From: Simon Davis
Sent: 09 November 2021 10:59
To: 'David Bennett' [REDACTED]
Cc: Dave Gilmore [REDACTED]
Subject: RE: CM/38/21/PL The Arundel Gardener and Maidenhead Aquatics

Please note that I will be recommending refusal but that the refusal will only be in respect of the shingled area in the south west corner. I have not drafted the refusal reason yet but it will be to do with the harm to the Listed Building, harm to residential amenity and encroachment into countryside. This position has been agreed with senior officers.

*As-Existing Site Plan
with Proposals*

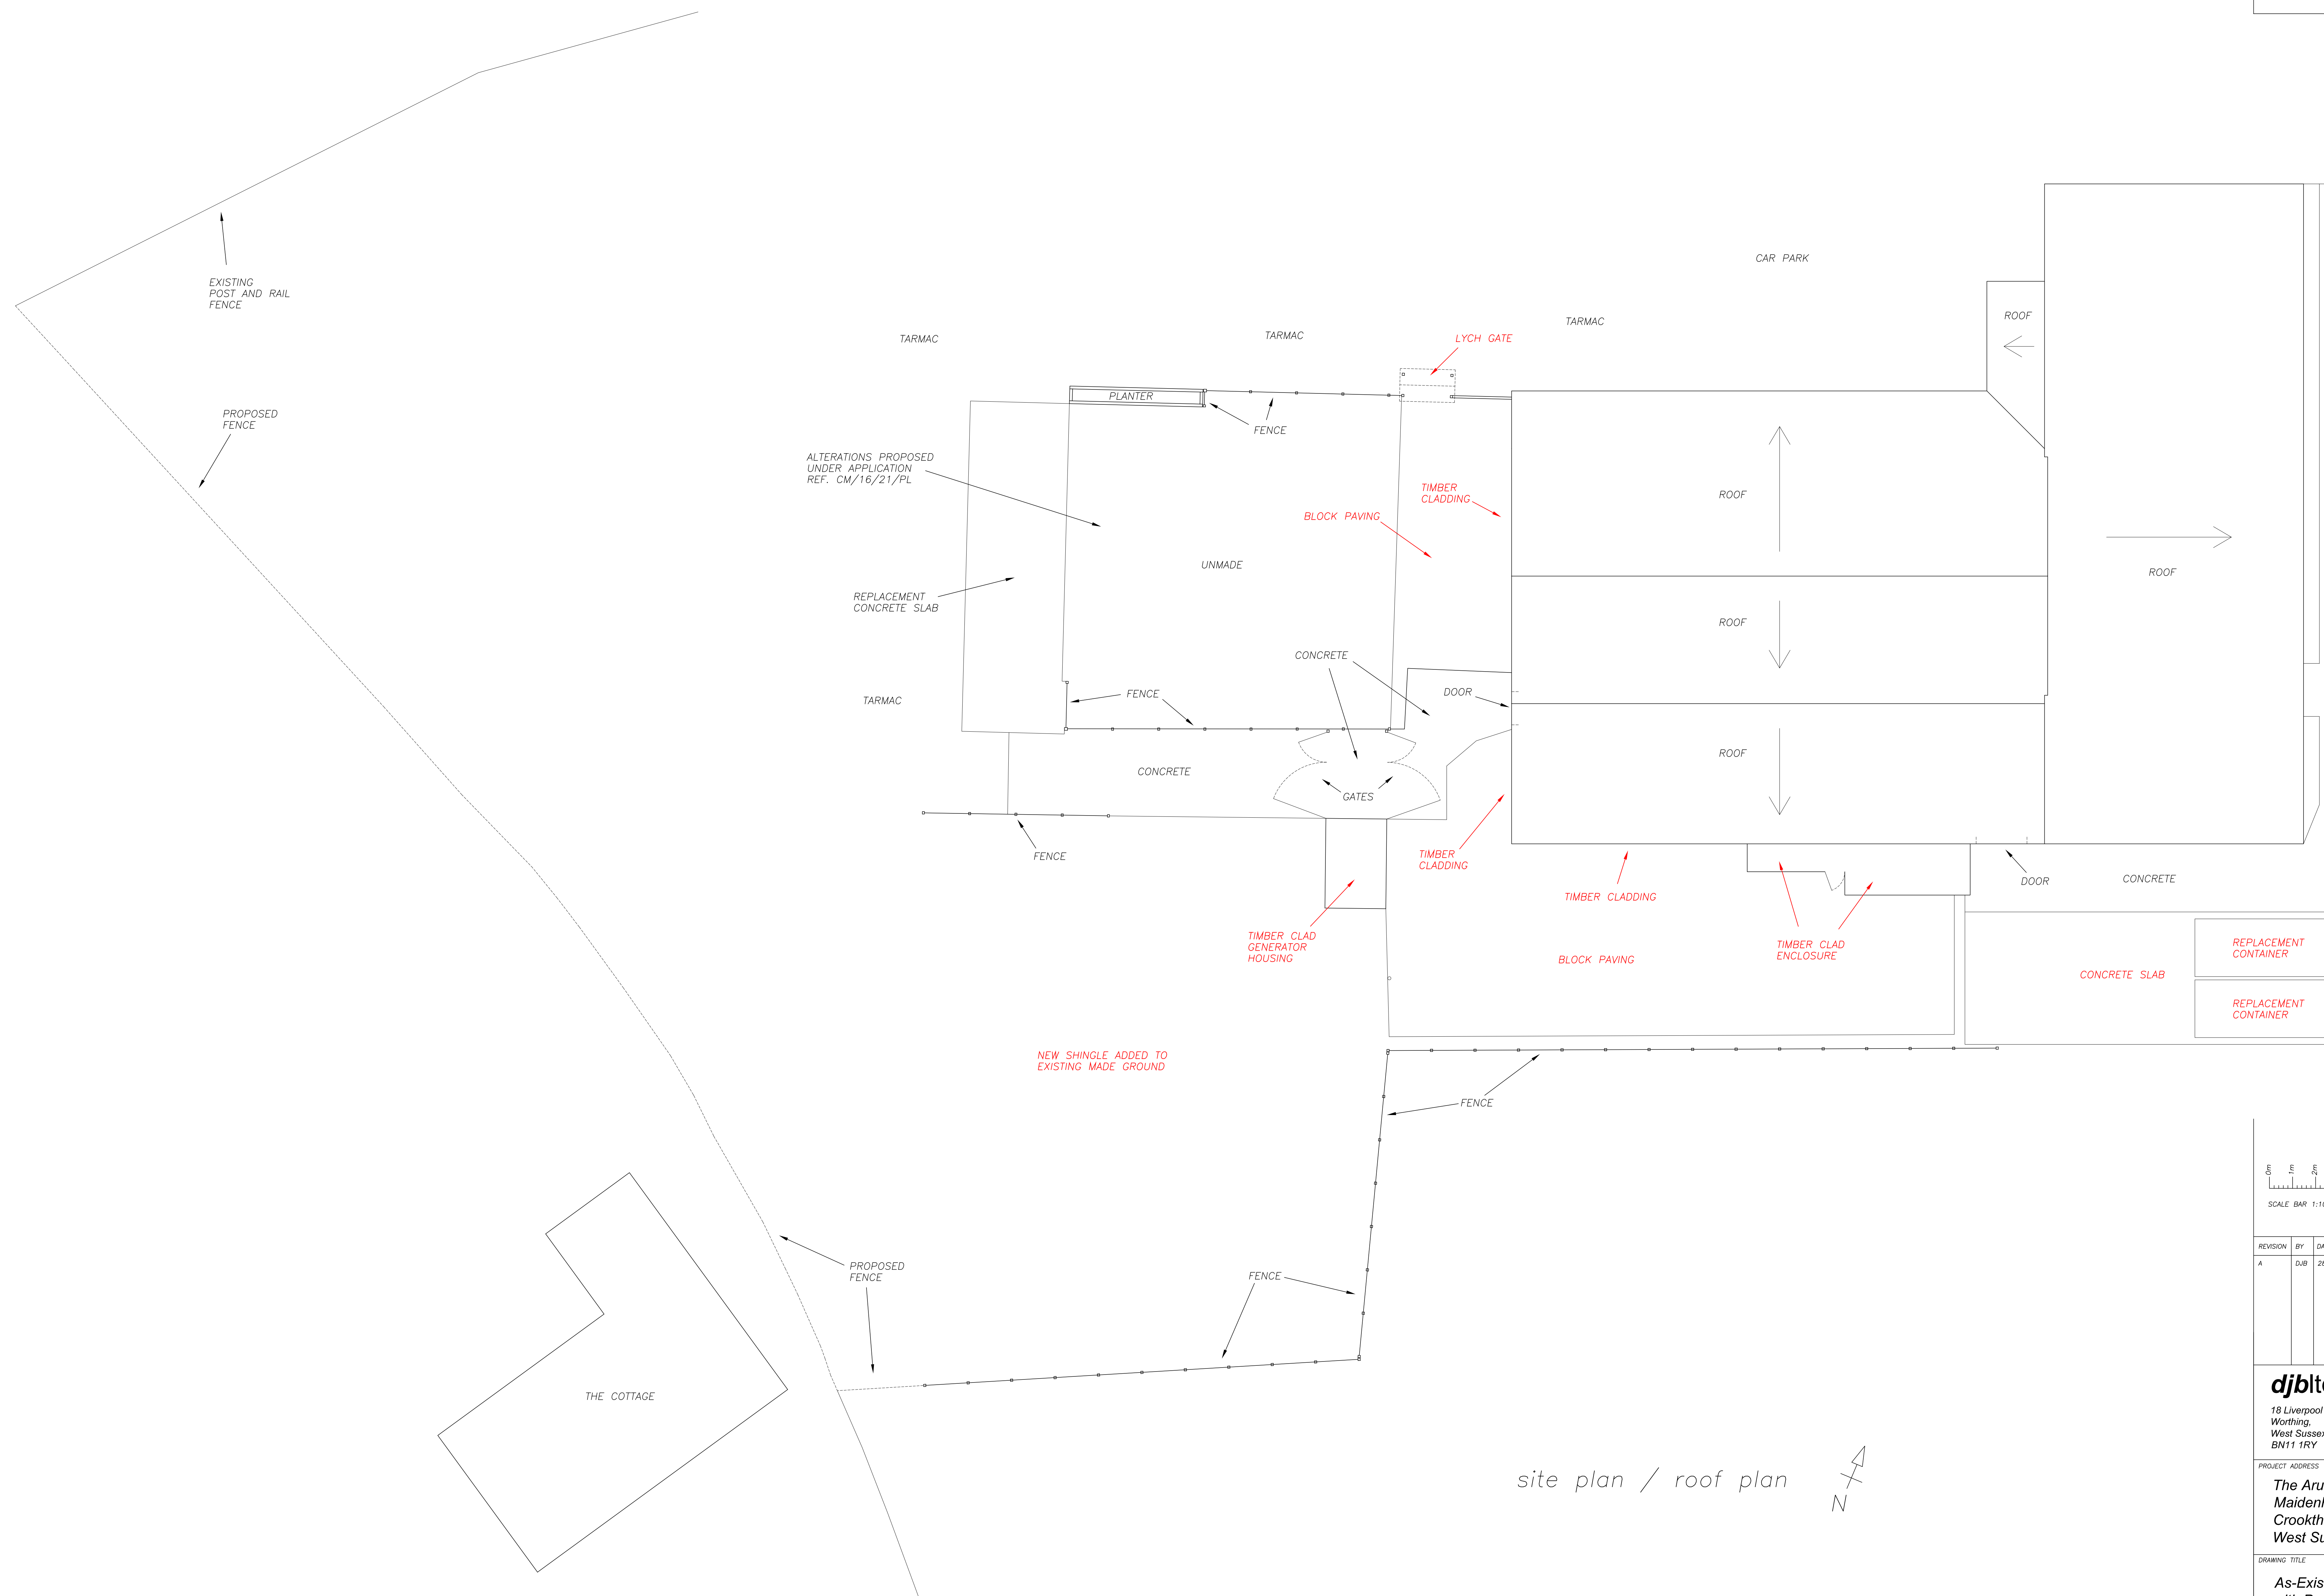
Could we remove the shingled area from the current application please so that the remainder can be approved.

Thanks for your email. Unfortunately we can't accept this change as due to the Parish objection, we cannot approve under delegated powers and our next Committee is not until the 4th January 2022. You can withdraw instead and then resubmit just for the acceptable elements.
